For Adrian Dowd

Proposed Plans

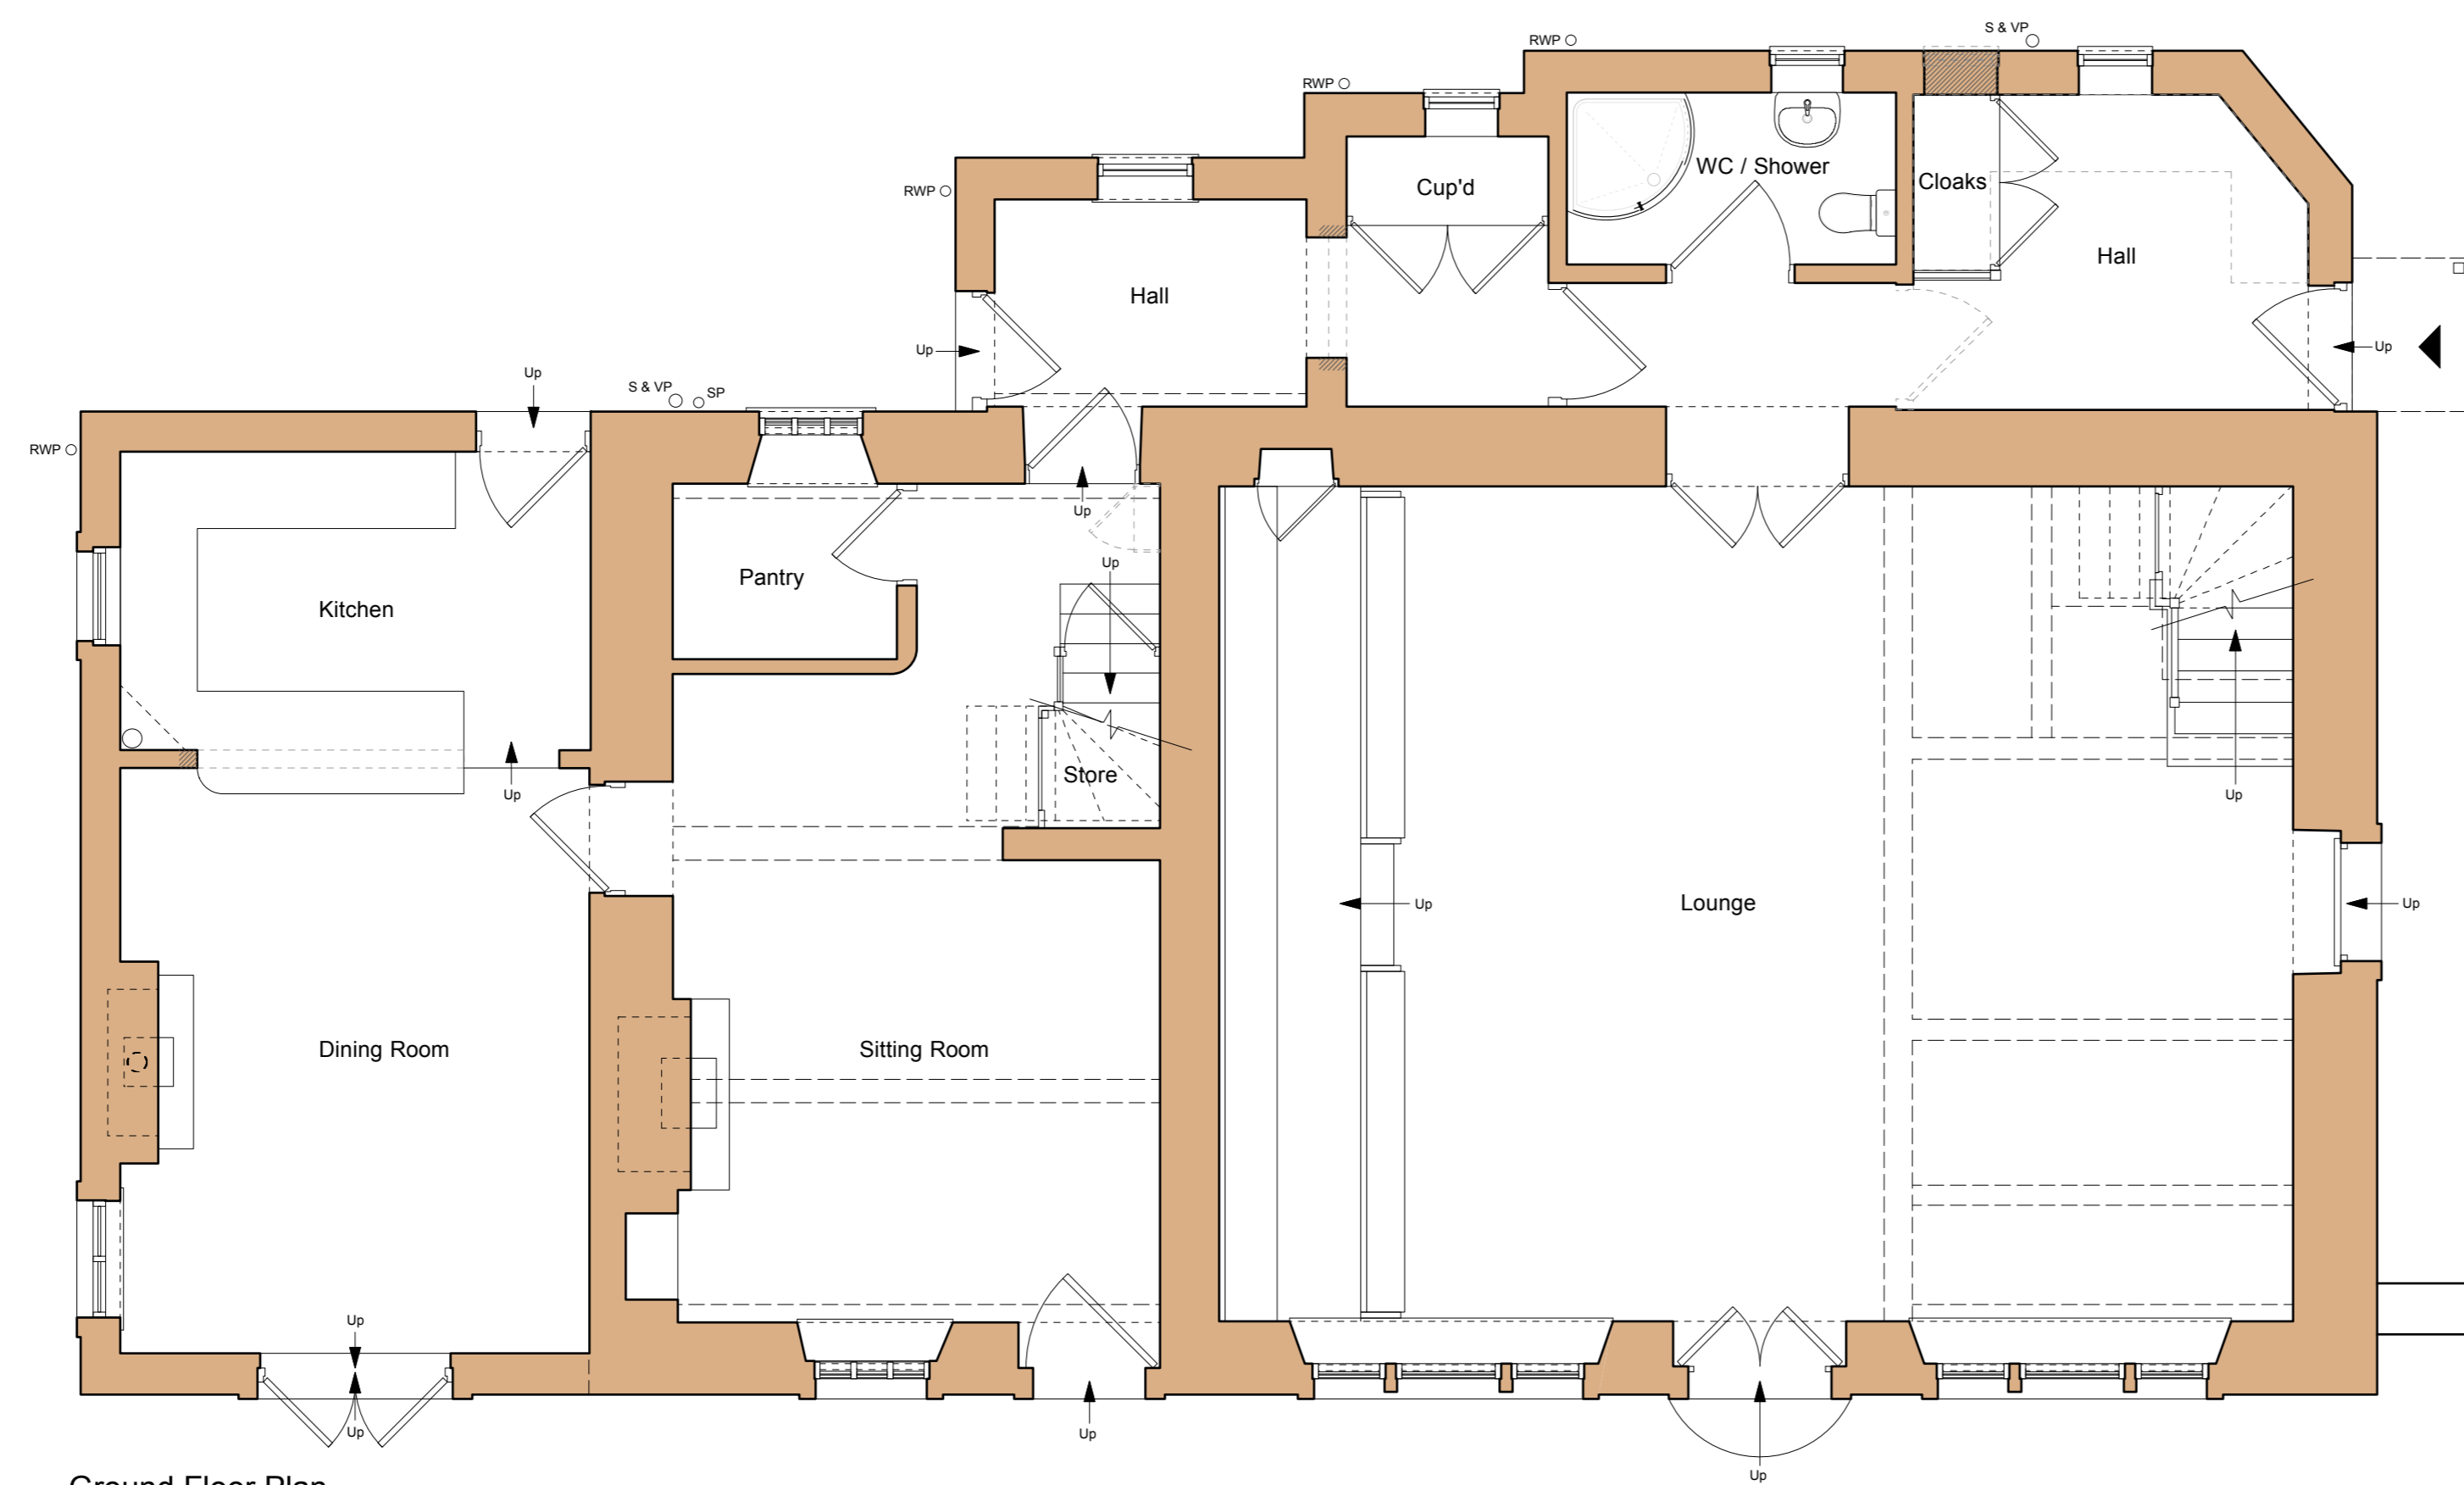
Comparison between the Existing and Proposal drawings implies that no alterations at all are in prospect for the interior of the Meeting House itself. This is of course welcome but is that really the case? Is the seating which is very important to the simple but evocative character to be wholly retained? . It is important too that the enclosed nature of the gallery (with its flap) is preserved as this is pivotal to the gender differentiation which is so fundamental to the historic character.
